From: [REDACTED]
Sent: 09 September 2026 07:44
To: Planning
Subject: Additional information -Response to applicants [REDACTED] 3/2026/0629

[REDACTED].
Re: Objection to Planning Application 29 Chatburn Park Drive
Planning application: APPLICATION NUMBER 3/2026/0629

2
EXISTING NORTH
1 : 50

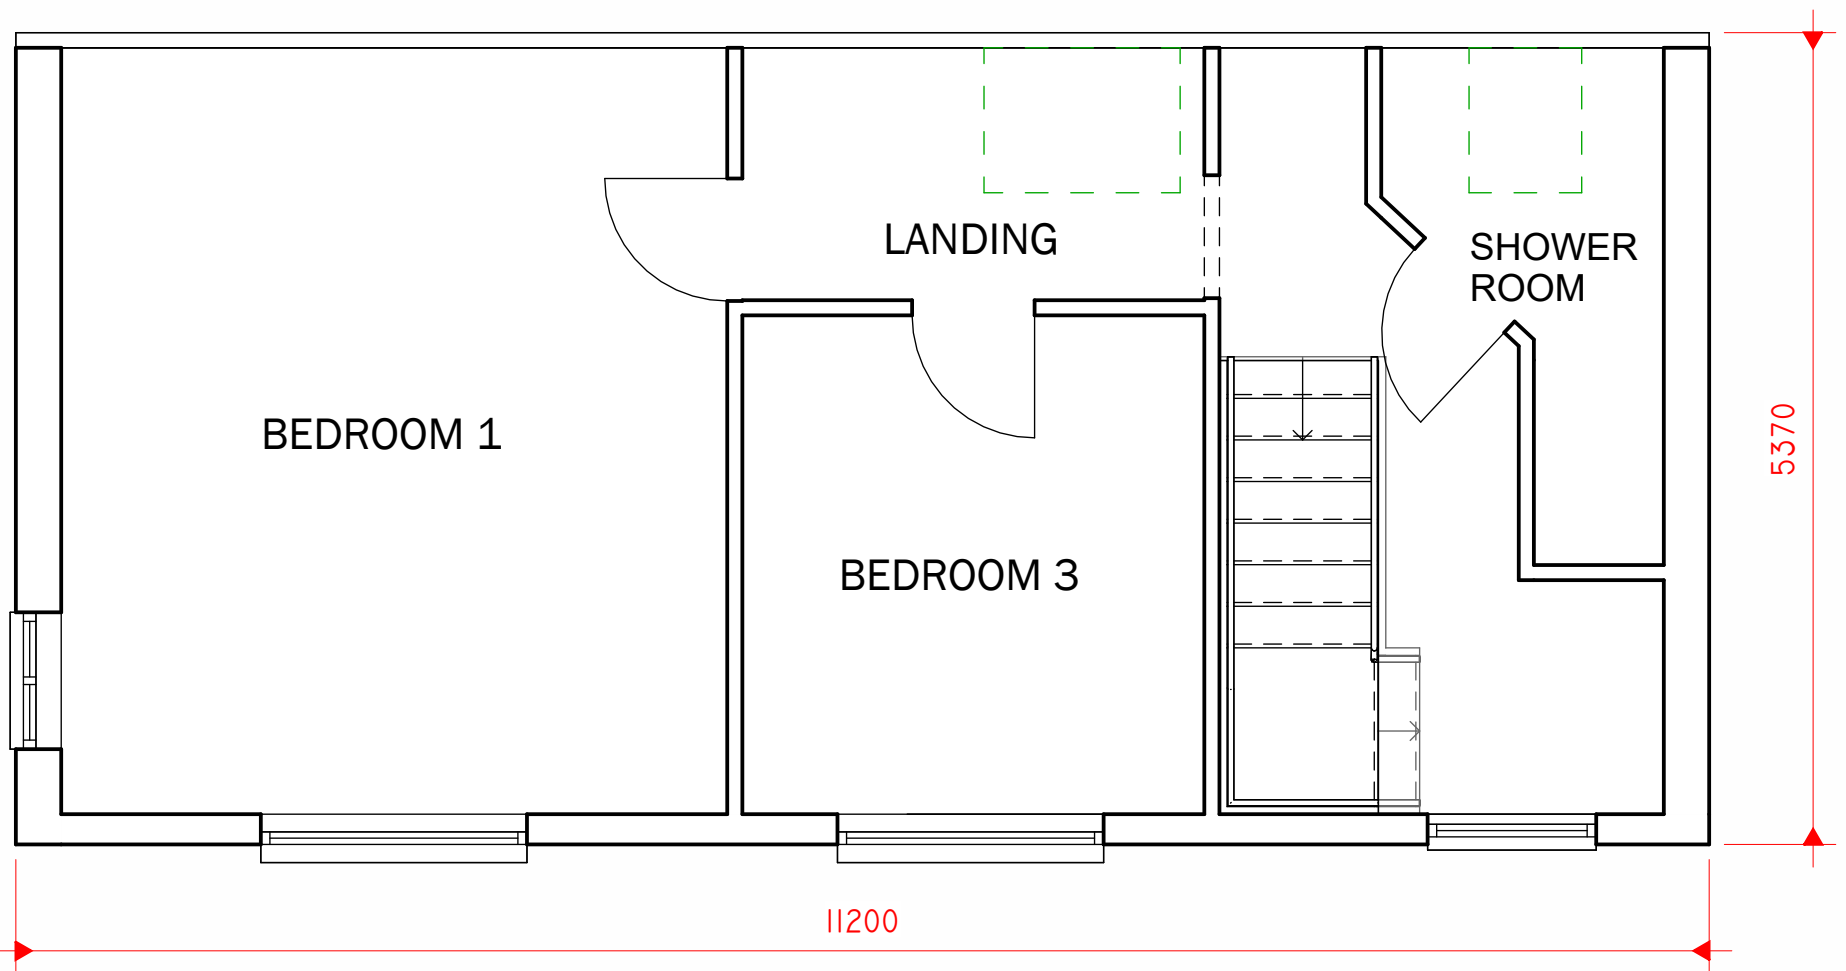
I further request that the LPA robustly pursue its current enforcement proceedings to compel the applicant to reinstall permanent, external obscure glazing to all five openings in strict accordance with the GPDO. (3 openings to south elevation, no 31, and 2 elevations to the north, no 27.

3
EXISTING SOUTH
1 : 50

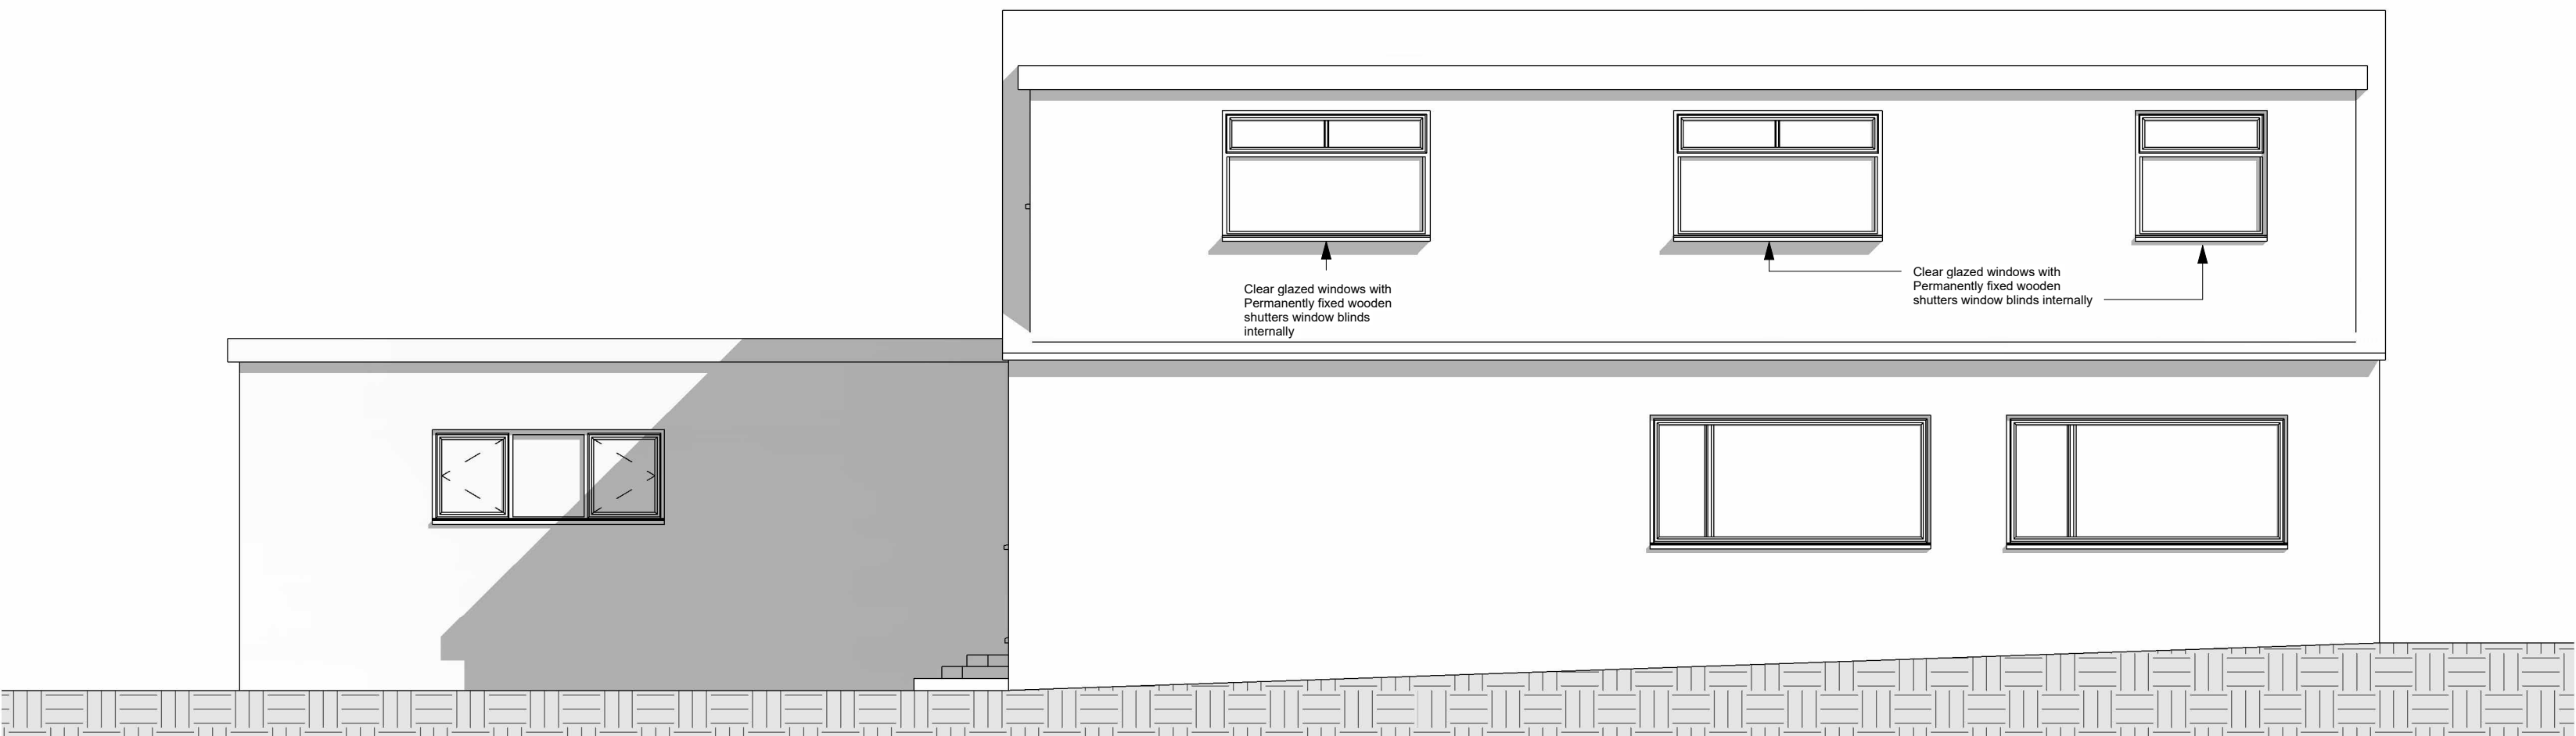
Also, the applicant's submission that internal wooden shutters mitigate the loss of privacy is entirely flawed and legally unenforceable under planning.
